**From:** planning  
**Subject:** FW: 170708 SB-PRVBC Re Weekly List App Ref 3/2017/0601.

**From:** Steve Burke [<mailto:sbcald@googlemail.com>]  
**Sent:** 17 July 2017 19:56  
**To:** planning  
**Cc:** 'R Michael Parkinson'; 'valerie grooby'; 'Janice Tolson'; 'Clegg Janet'; 'John Rowley'; 'Christopher Middleton'; 'Geoff'  
**Subject:** 170708 SB-PRVBC Re Weekly List App Ref 3/2017/0601.

Having reviewed to this week's list of applications for w/e 170707 the only one Clitheroe Civic Society believe we need make comment on is the application at **50 King Street, Clitheroe, Lancashire BB7 2EU Application Ref: 3/2017/0601.**

Proposed Garage Plan and Elevations

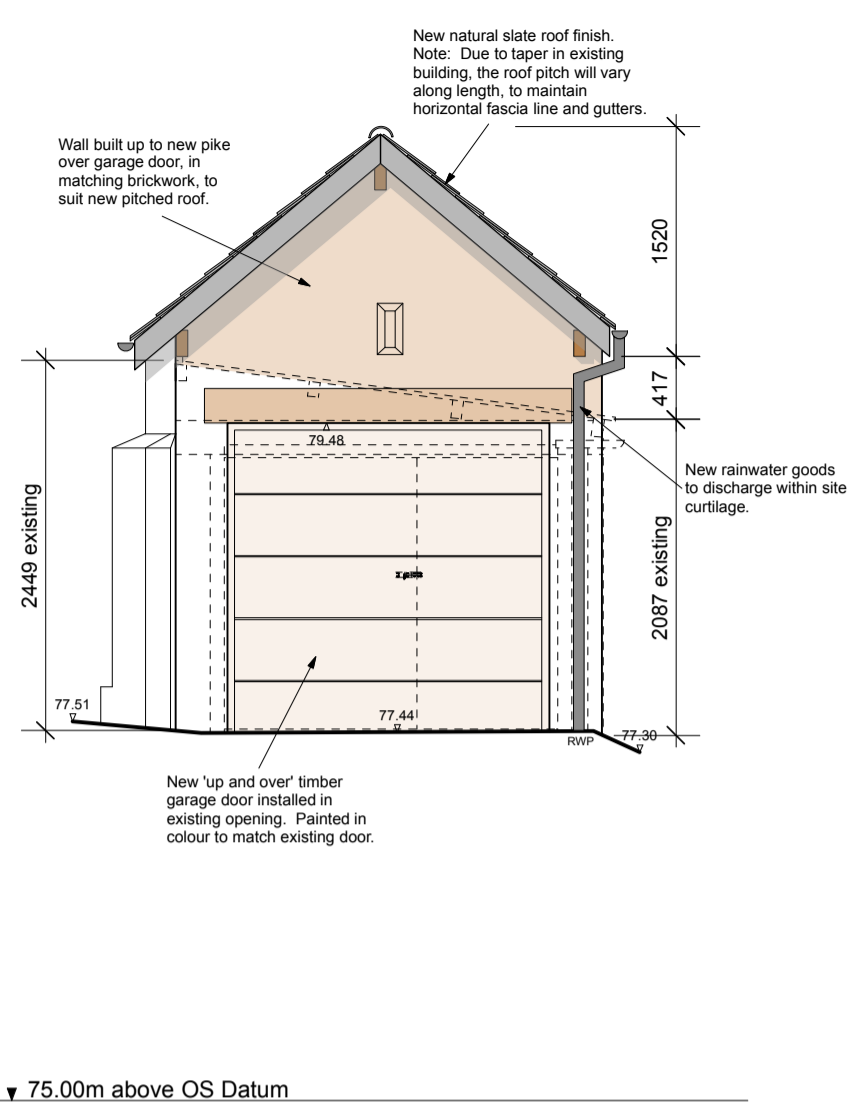
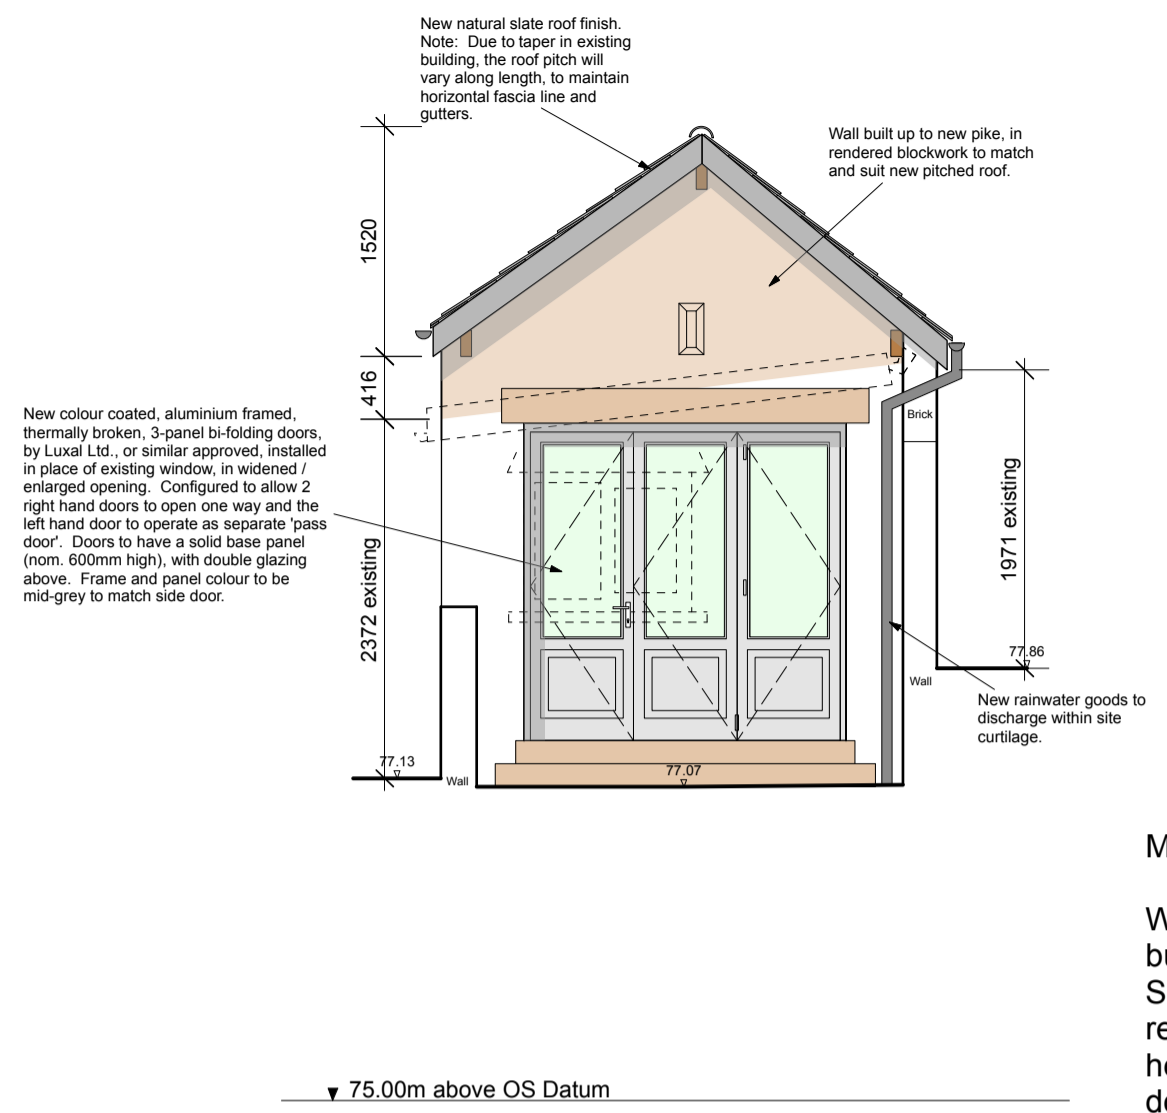
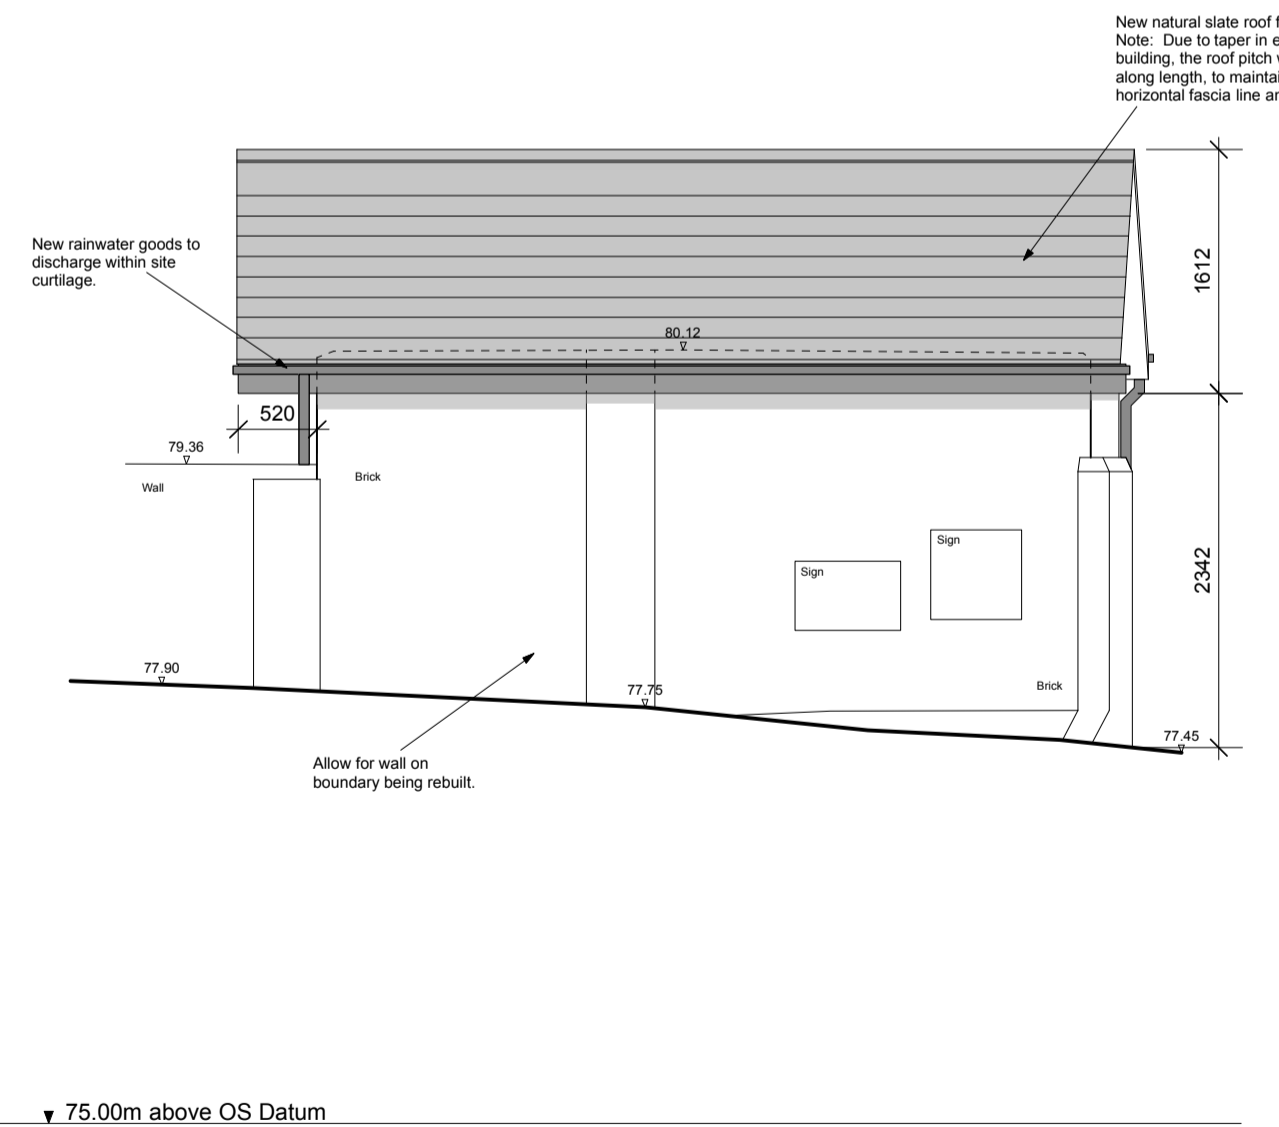
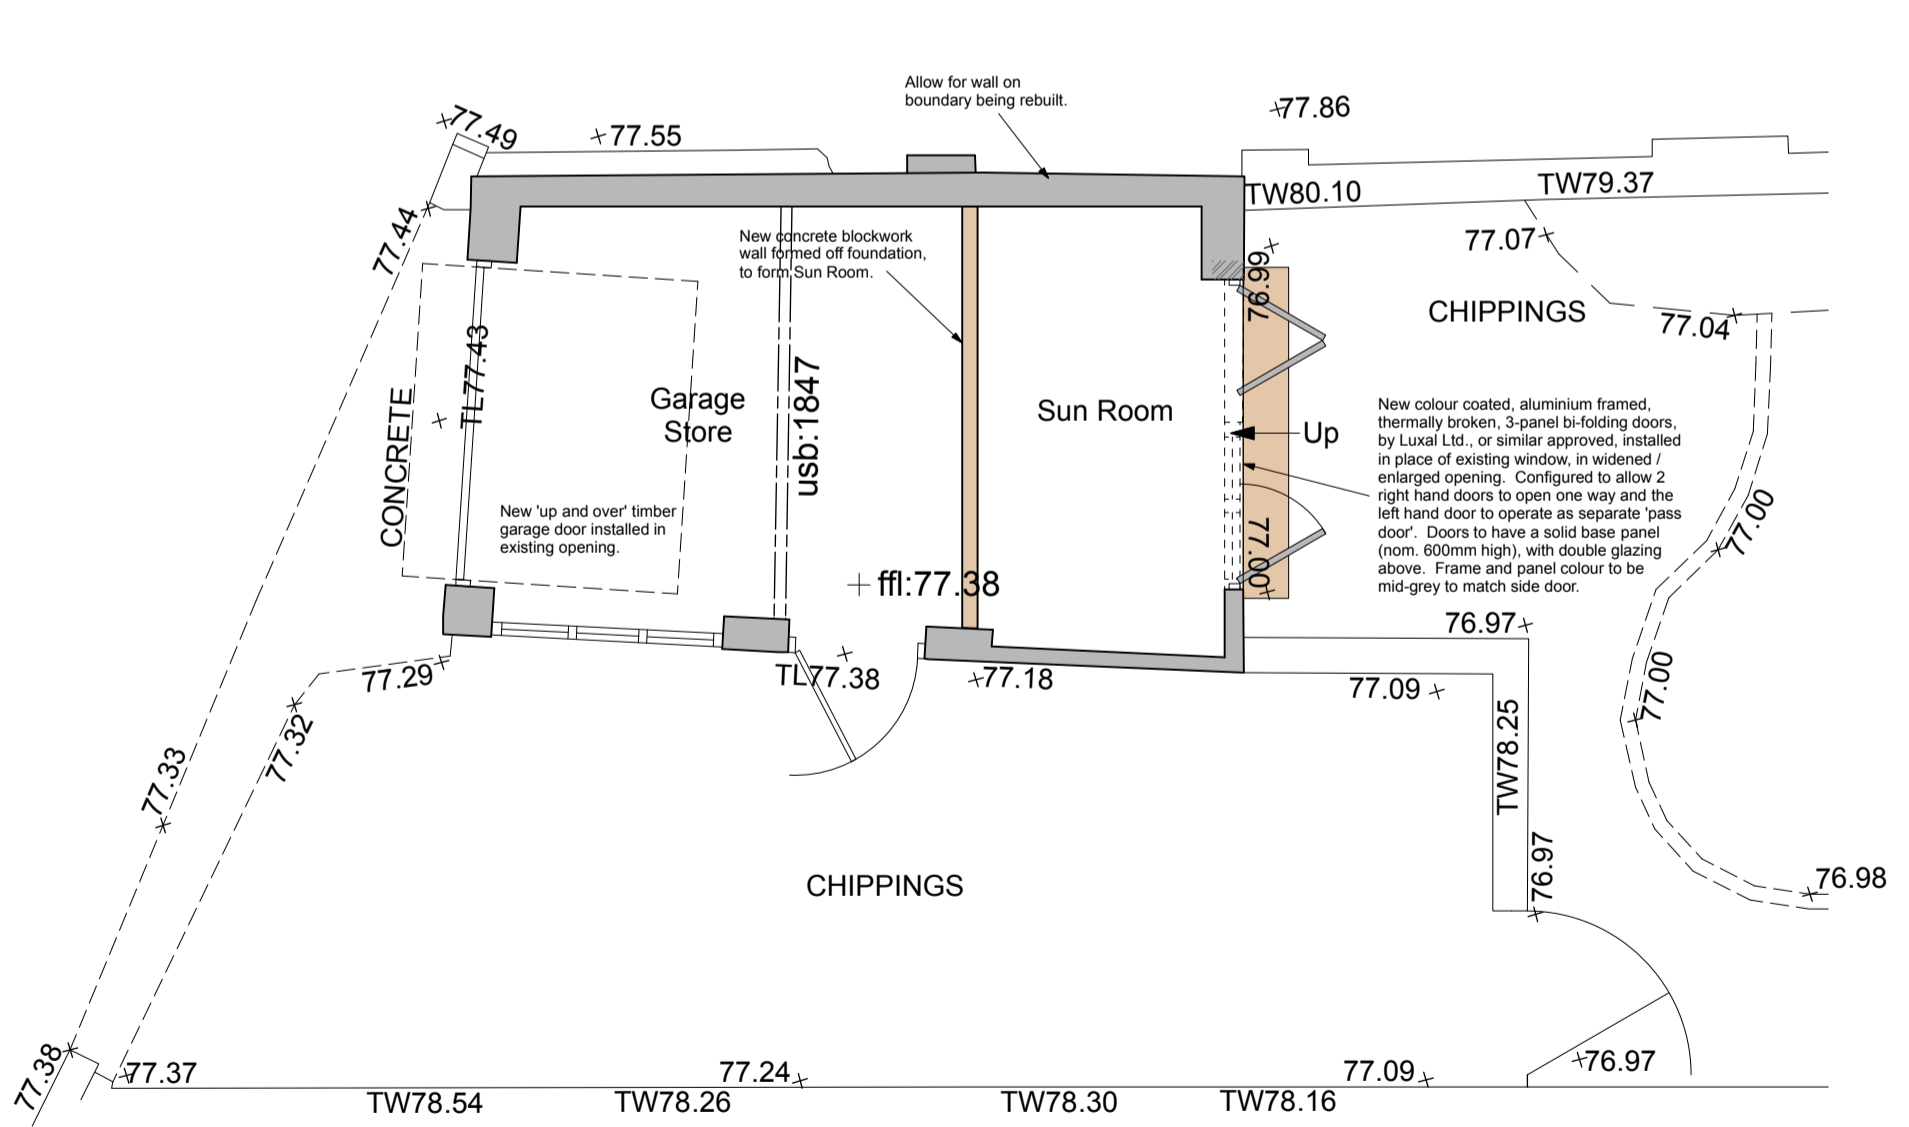
From the 'Pre Application Process and Response Statement' it is clear that the Applicant and their Architect are at odds with the Planning Officer's observations and recommendations, the principle objection being that *'the height of the roof would increase by approx. 1.70m and due to the width of the building the roofline would appear prominent. ....the resultant changes would result in a disproportionately sized building which appears prominently within the public realm detracting from the visual appearance of the property it relates to and the wider Conservation Area. ... the height of the building as a result of the replacement pitched roof should be no more than 3 metres.'*

The applicant and Architect have considered this but, on the grounds that other external ancillary buildings along Back King Street have similar and higher elevations than the proposals in this application, have not accepted this advice..

Having considered both arguments, and visited the site, CCS **supports all of the proposed alterations as submitted** and for the following reasons:

In this instance our recommendation is that permission be granted for this modest proposed development as submitted and for the reasons stated above.
